The Sizewell C Project

SZC Co.'s Response to the Secretary of State's Request for Further Information dated 25 April 2022: Appendix 1 - Response to Mr Scarr's Submission.

SZC CO.'S RESPONSE TO MR NICK SCARR'S CORRESPONDENCE TO BEIS REGARDING EN010012 18TH MARCH 2022 SECTION 5 'COASTAL CONSIDERATIONS'

Plate 7.2: Sizewell C Spent fuel management strategy.

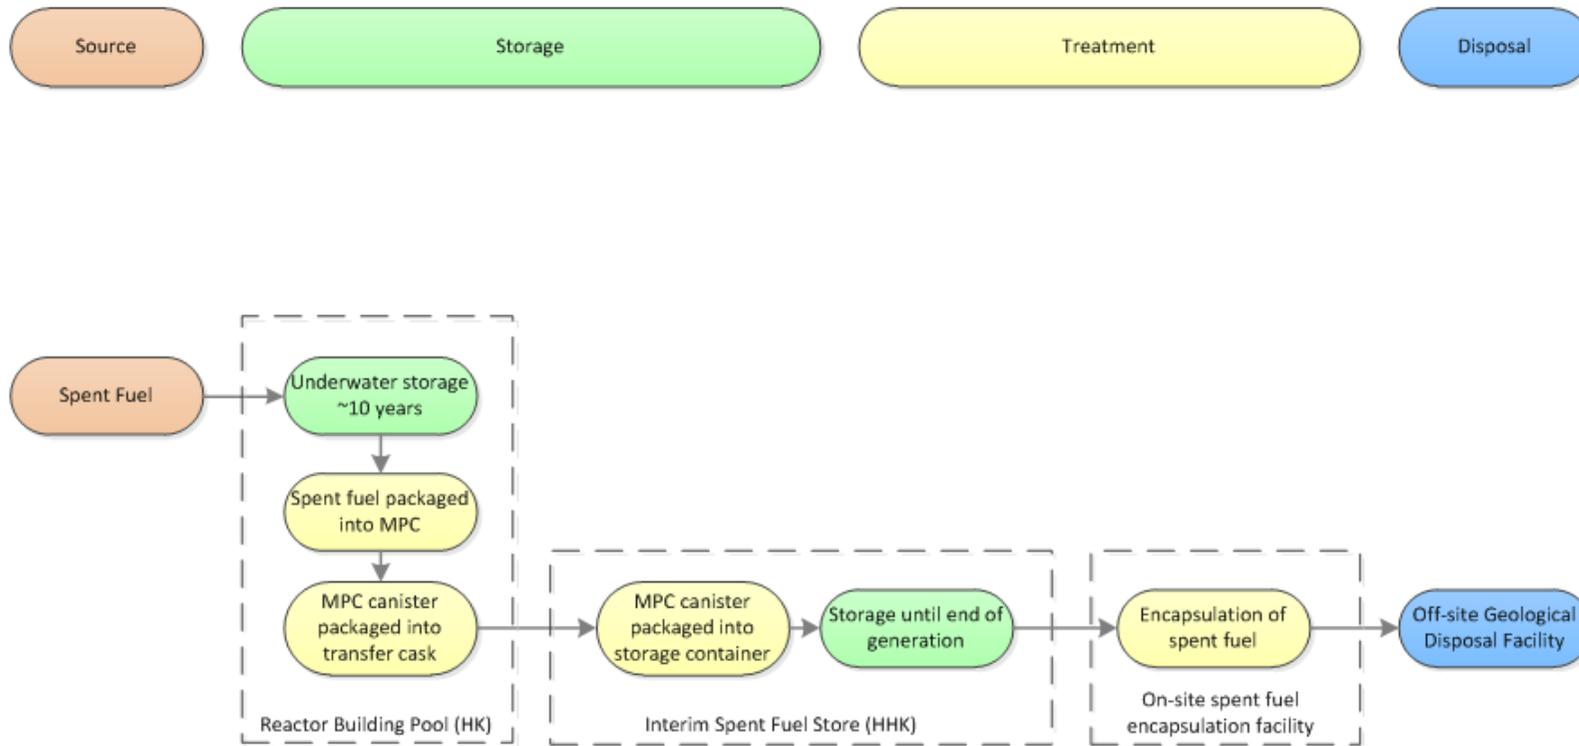
Paper 2 - Sizewell C and the Applicant's claim for spent fuel removal by 2140. Is this a plausible timeframe?		
16	NS	Spent fuel will be classified as waste. This is currently not the case.
	SZC Co	SZC Co has developed its approach to decommissioning, radioactive waste disposal and spent fuel management in compliance with legislation, policy and guidance set out by the UK Government and Regulators.
17	NS	That there are no over-runs in construction time of Sizewell C and that there are no lifetime extensions to Sizewell C.
	SZC Co	The 2008 Energy Act requires all prospective operators of new nuclear power stations in the UK to have an approved Funded Decommissioning Programme (FDP) setting out the operator's approach and costed plans for decommissioning the power station, which SZC Co will deliver prior to the commencement of construction. As part of the FDP, SZC Co will also provide a Decommissioning Waste Management Plan (DWMP) to demonstrate a credible plan for the long-term management of wastes, particularly "higher activity" wastes and spent fuel.

20	NS	That the GDF can accept and consign Sizewell C's spent fuel at the same time as other nuclear waste if necessary. It is not at all clear that this will be the case.
	SZC Co	Please refer to the response provided in this document at Ref 19 above.

Ref	Who	Question / Answer
21	NS	That the timeframe (considered to be 100 years as far as I am aware) for the deposition of other committed nuclear waste to be consigned prior to Hinkley C and Sizewell C— that is, legacy nuclear waste, including spent fuel from power stations and the highly enriched submarine spent fuel— operates within the allocated timescale without over-run.
	SZC Co	Please refer to the response provided in this document at Ref 19 above.

Ref	Who	Question / Answer
		In accordance with the Nuclear Site Licence, the DWMP and Safety Case will be periodically reviewed to ensure adequacy of the flood defences, facilities for managing radioactive waste and spent fuel along with the decommissioning plan, should the life of the plant be extended, or disposal times change.
18	NS	That one accepts the validity of the ONR's downward revision of the required cooling period specified by the NDA from 140 years to 55-60 years.
	SZC Co	Spent fuel cooling rates are specific to the type of fuel and the burn up of the individual assemblies, but it should be noted that no fuel will be sent from the SZC site until it meets the transport and Geological Disposal Facility (GDF) acceptance criteria.
19	NS	That a GDF is available within 120 years, and it will take no more than 10 years to consign the Sizewell C spent fuel.
	SZC Co	<p>The Long-term Nuclear Energy Strategy from the UK Government states that higher activity wastes, which includes spent fuel, are to be placed in a GDF. As one is not currently available, these spent fuels will require on-site storage with a conservative estimate provided by Nuclear Waste Services (formerly Radioactive Waste Management Ltd.) of up to 100 years. As such the Interim Spent Fuel Store at SZC has been designed with an operating life of 100 years. The facility has been designed such that it would be capable of extension beyond this point if necessary subject to any required refurbishment and/or replacement of equipment.</p> <p>Through compliance with UK Government and regulatory policy and guidance, SZC will ensure the safe management of spent fuel and radioactive waste, regardless of removal date</p>

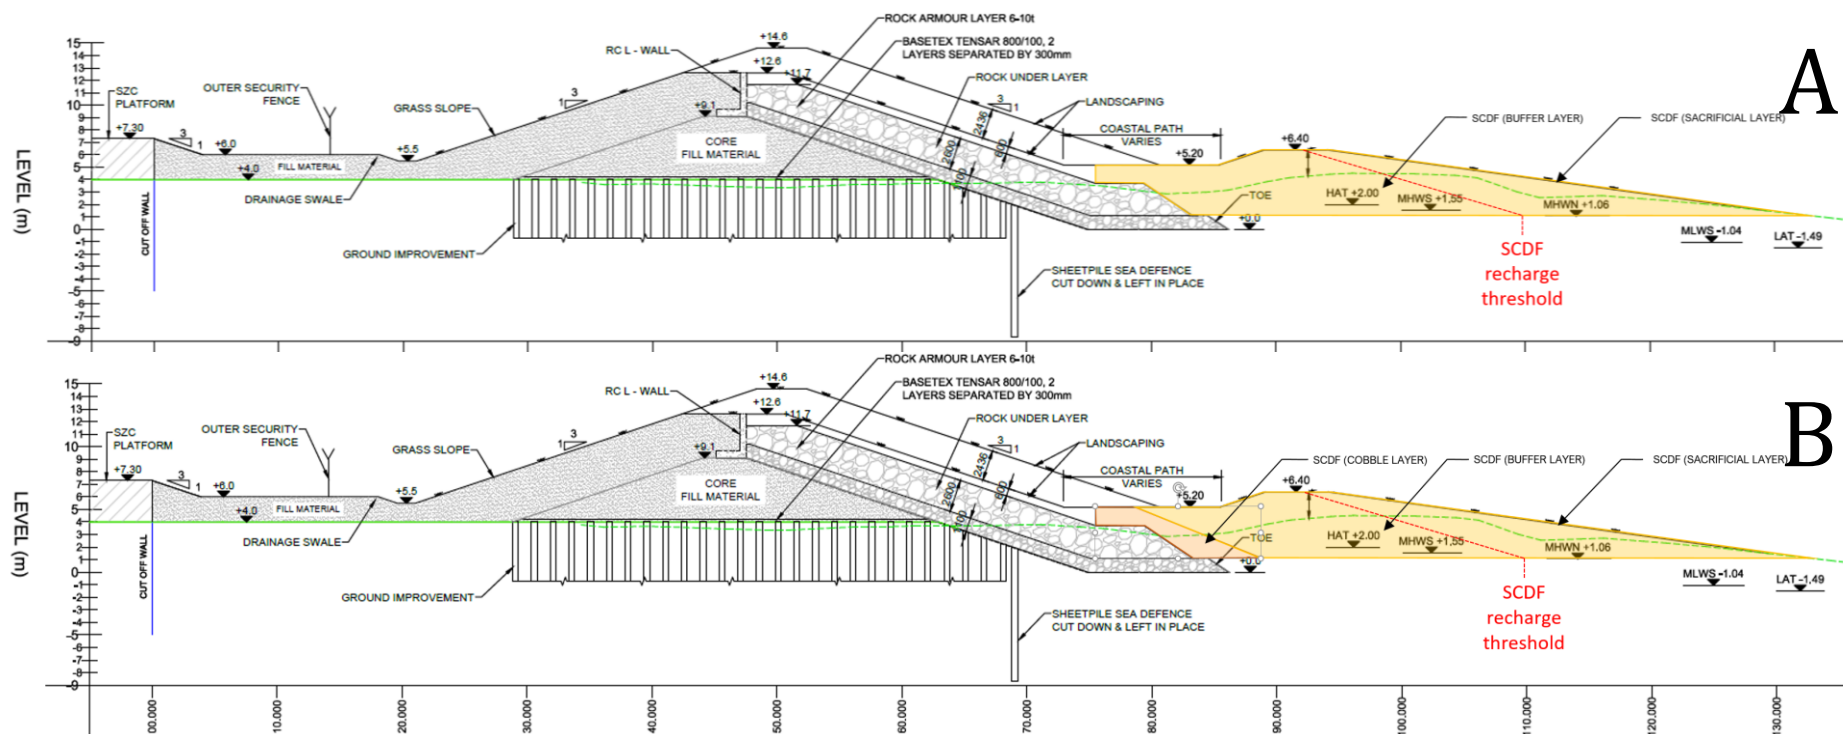
Ref	Who	Question / Answer
2	NS	<p>Important points relating to TR544 REP10-124:</p> <ol style="list-style-type: none"> 1. A 1:107 storm sequence is claimed to ‘...occur once or twice within the whole project lifetime of Sizewell C’. This can be expressed in another way – over the project lifetime (2022-2190) a span of 168 years there is a 79.4 % chance of its occurrence. See https://www.weather.gov/epz/wxcalc_floodperiod 2. The 1:107-year return period claimed for the Beast from the East storm refers to cumulative wave power only and not storm surge. Should the ‘79.4% chance of a Beast from the East storm’ coincide with a significant storm surge or significant climate change sea level rise the repercussions to the SCDF could be manifestly different. 3. The Applicant claims that it has ‘conservatively modelled’ by using ‘...the future receded shorelines topography in line within the previous section.’ This is previously claimed as being the severely receded shorelines (Sections 3.2.2 and 3.2.3, respectively. See TR544 REP10-124 3.2.2 Page 44. The ‘severely receded shoreline’ claimed by TR544 is shown following (Page 49 TR544 REP10-124) <p>In my view, this shoreline cannot be regarded as ‘severely receded’ and hence cannot be regarded as ‘conservative modelling’.</p> <ol style="list-style-type: none"> 4. TR544 has a reliance on the idea that sediment and shingle is ‘...effectively confined to the system (and is also likely to increase once Dunwich Cliffs begin to erode)’ see Page 45 TR544. This statement is not supported by evidence in the Applicant’s own BEEMS documentation as follows: “The last 2 to 3 decades of strong erosion at Dunwich were not matched by ongoing accretion in the south.” BEEMS TR223 Table 12, shows net erosion of the Sizewell C foreshore since 1993.

4	NS	<p>The SCDF and the HCDF of the proposed Sizewell C do not protect the landward side of the main nuclear platform, a side exposed to the low-lying, contiguous Sizewell and Minsmere marshland which is highly vulnerable to shoreline recession risk should there be loss of the Dunwich bank. See REP2-393.</p>
	SZC Co	<p>SZC Co. notes that assessment of the above risk has previously been considered in the response to ExQ2 CG.2.10 [REP7-056] (iv) which states: <i>“Degradation of the Sizewell-Dunwich banks would not have an impact on extreme still water levels and therefore would not increase the risk of inundation to the landward side of the main development platform. In the event of shoreline recession to the north or south of the proposed Sizewell C site, wave overtopping of the existing coastal defences and further wave propagation behind the existing Sizewell A and Sizewell B stations would result in wave energy dissipation, and the wave action at the landward side of the main development platform would therefore not be significant.”</i></p>

SZC Co	<p>The modelling underpinning BEEMS Technical Report TR544 [REP10-124] can be found in TR545 [REP9-020]. The water levels and waves used for the Beast from the East model came directly from measurements of that event at Sizewell. Beach erosion under storm surge was tested using the design storm that included:</p> <ul style="list-style-type: none"> • a 1 m storm surge occurring at high tide (springs) and

Ref	Who	Question / Answer
		<ul style="list-style-type: none"> the instantaneous 1:20 year wave height (i.e., notionally occurring for one hour every 20 years) held constant for 13-hours. <p>Although the historical patterns of sediment supply from Dunwich Cliffs to Minsmere and Sizewell Beaches are not always clear, this is not significant in terms of the evidence included in BEEMS Technical Report TR544 because the coastal defence system at Sizewell C and the numerical modelling (including the use of receded shorelines) underpinning BEEMS Technical Report TR544 [REP10-124], has no reliance on sediment from the cliffs or the behaviour of Dunwich Bank.</p> <p>Should higher than expected sea levels and a potentially lowered Dunwich Bank increase wave energy acting on the cliffs, leading to erosion, then a mixture of sand (0.06 – 2 mm) and pebble-sized (2 – 64 mm) sediments would be eroded and transported south towards Minsmere and Sizewell shorelines.</p> <p>If the eroding cliff sections produce pebbles, beach volumes will increase and the pebbles would largely remain within the Greater Sizewell Bay. This was demonstrated through evidence from shingle tracer studies, numerical modelling and sediment distribution maps included in Volume 2 Appendix 20A of the ES ([APP-312]). Were this to occur, the frequency of SCDF recharges could decline as a result of the additional supply of pebbles. To increase the conservative nature of the evidence presented in BEEMS Technical Report TR544 [REP10-124], no account was taken of the supply of pebbles from Dunwich Cliffs to increase the volume of the SCDF.</p> <p>If the eroded cliff sections are primarily sandy, those sediments are expected to move along the subtidal longshore bars and be mixed in and out of the subaerial beach, not necessarily contributing to long-term beach volumes. This is one reason why historical erosion of Dunwich Cliffs does not always translate into accretion on Minsmere and Sizewell beaches (the distribution of eroded sediments themselves may vary but the material is retained with the overall system).</p> <p>Mr Scarr does not provide any rationale in support of his view that the adjacent shoreline recession case is not ‘severely receded’. The severely eroded adjacent (to the SCDF) shoreline case is derived from the EIA evidence base (Section 7.7 of Appendix 20A, Volume 2 of the Environmental Statement [APP-312]), agreed with the regulators and conservatively takes no account of additional sediment supply arising from the SCDF (which would have acted to counter this degree of recession).</p>

Ref	Who	Question / Answer
		<p>This case (approximately 85 m relative to the SCDF) is fit for its purpose of testing SCDF viability under the conditions of high longshore transport and SCDF erosion rates, which would be expected for receded adjacent shorelines. Despite the higher rates of SCDF sediment loss in this simulation, the SCDF was still shown to be viable across the life of the station (to 2140) [REP10-124].</p> <p>The case for why the modelling is conservative is made in BEEMS Technical Reports TR544 and TR545 [REP10-124 and REP9-020, respectively] and reiterated in the response to the response given at Ref 6 of this document below.</p> <p>Given the importance of particle size, the text preceding the quote in Nick Scarr’s point 4 “TR544 has a reliance on the idea that sediment and shingle is ‘...effectively confined to the system...’ is taken out of context. In full, the quote in TR544 states ‘(i) sand supply is expected to remain similar or increase (Brooks and Spencer, 2012), (ii) shingle is effectively confined to the system (and is also likely to increase once Dunwich Cliffs begin to erode)’ That is, the pebbles are confined to the system, but the sand is not.</p>
